Our ref: DOC21/59878

Notice of Exhibition of application for Mount Pleasant Optimisation Project (SSD – 10418)

Thank you for your referral dated 2 February 2021 inviting comments from the Heritage Council of NSW on the above State Significant Development (SSD) proposal.

Heritage NSW

Figure 14: Historic Heritage Sites

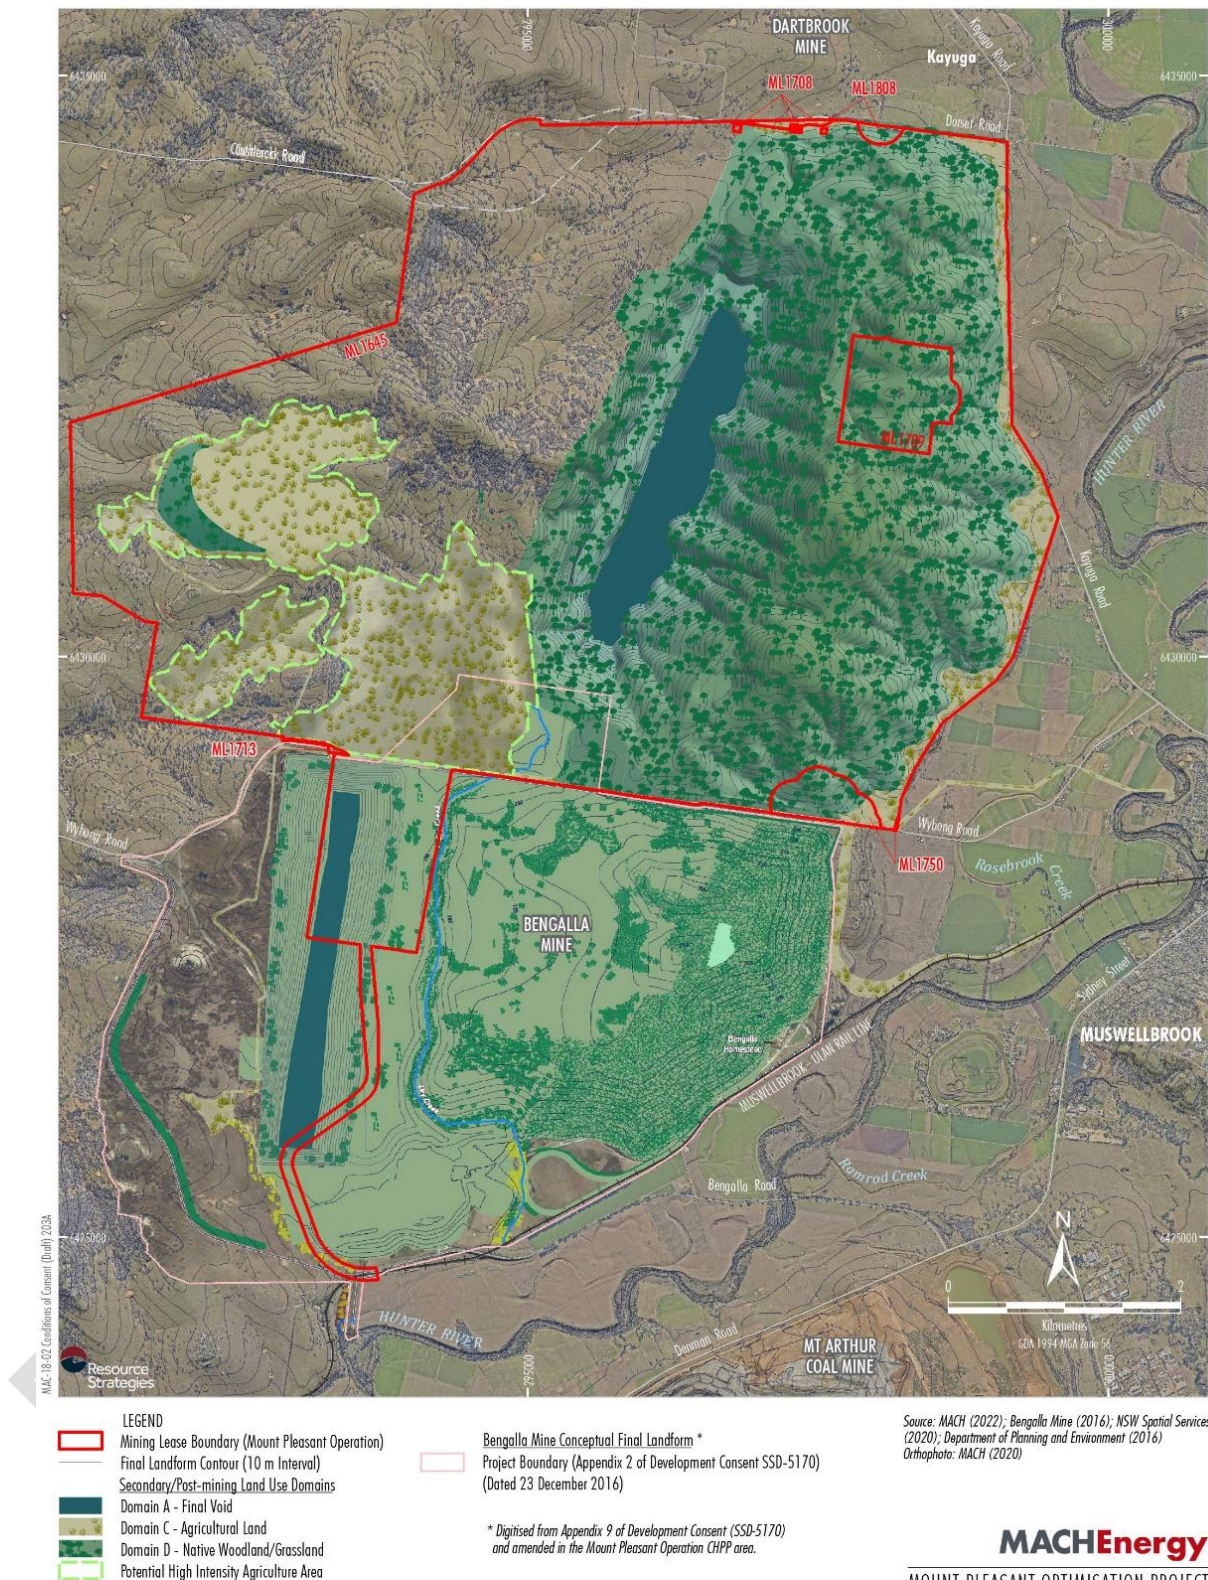
The reassessment concluded for a number of sites, where a well is present it would not require further investigation (e.g. MP13, MP23, MP25, MP38). It is unclear if these wells contain any artefacts, objects or deposits which would be 'relics' under the *Heritage Act, 1977*. Extent argued in each case that 'the well would not constitute a relic under the *Heritage Act*, being rather a work under the legislation' (Extent 2020). This is only partly correct, 'environmental heritage' as defined under s.4 of the *Heritage Act 1977* is interpreted to mean that each item is mutually exclusive, therefore a relic is not a work. That interpretation is provided in the Guideline 'Assessing Significance for Historical Archaeological Sites and Relics' (2009). There is no definition for a 'work' under the *Heritage Act, 1977*. Extent has concluded in most instances that these sites have a low potential for relics elsewhere, however it is unclear if the wells contain artefacts. If present would the artefacts retain research potential and be considered relics? HNSW requests that the Extent Assessment reviews the sites which contain wells to clarify this question of the presence of relics and further management. This is requested for the project's RTS phase.

The assessment for MP49(a-c) should be reviewed to confirm the conclusions for the site based on the existing levels of research. It is noted that its current phasing and likely occupation is linked predominately to the Weidmann Family from the late 19th century, rather than a much earlier time period. The Extent argument is based on a limited timeline sourced from VAHS 2014 and does not fully explain an argument for limited research potential. Clarification about the historical research and significance for this item (MP49) is requested for the project's RTS phase.

Extent's Assessment identified sites MP23 (Devine's) and MP27 (Thorndale) may contain unconfirmed potential for child burials. If of significance, these remains may also be relics under the *Heritage Act, 1977*, however this is not clear from the summary research presented. Legislative requirements within the Public Health Act and Public Health Regulation (and definition of a 'relic' under the *Heritage Act 1977*) have been updated since the publication of the 1998 Heritage Council Guideline 'Skeletal Remains'. If human remains are identified, NSW Health are likely to require the names and next of kin to seek approval for exhumation (where required by the SSD). Exhumation is approved under the Public Health Regulation 2012. The timing of these activities (investigation) and appropriate and sensitive management of discovery of human remains including contact with relatives, should be appropriately factored into the project, if approved. Relevant commitments and requirements should be updated for the project's RTS phase.

- Negoa Estate (MP41)
- Rosebrook (MP38)
- Overdene (Overton) (MP52)

MP52 (Overdene/Overton), is 700m outside the SSD boundary and managed under a separate planning approval. It is unclear how this approval would achieve actions such as the adaptive reuse that is recommended. It is recommended that the item's significant values are used to guide any planning/management decisions in future.

The mine's identified commitment to avoidance of impact to MP51 (Kayuga Bridge) through a 'no access for mining vehicles' strategy is supported. The avoidance of MP53 (Kayuga Cemetery) is also supported.
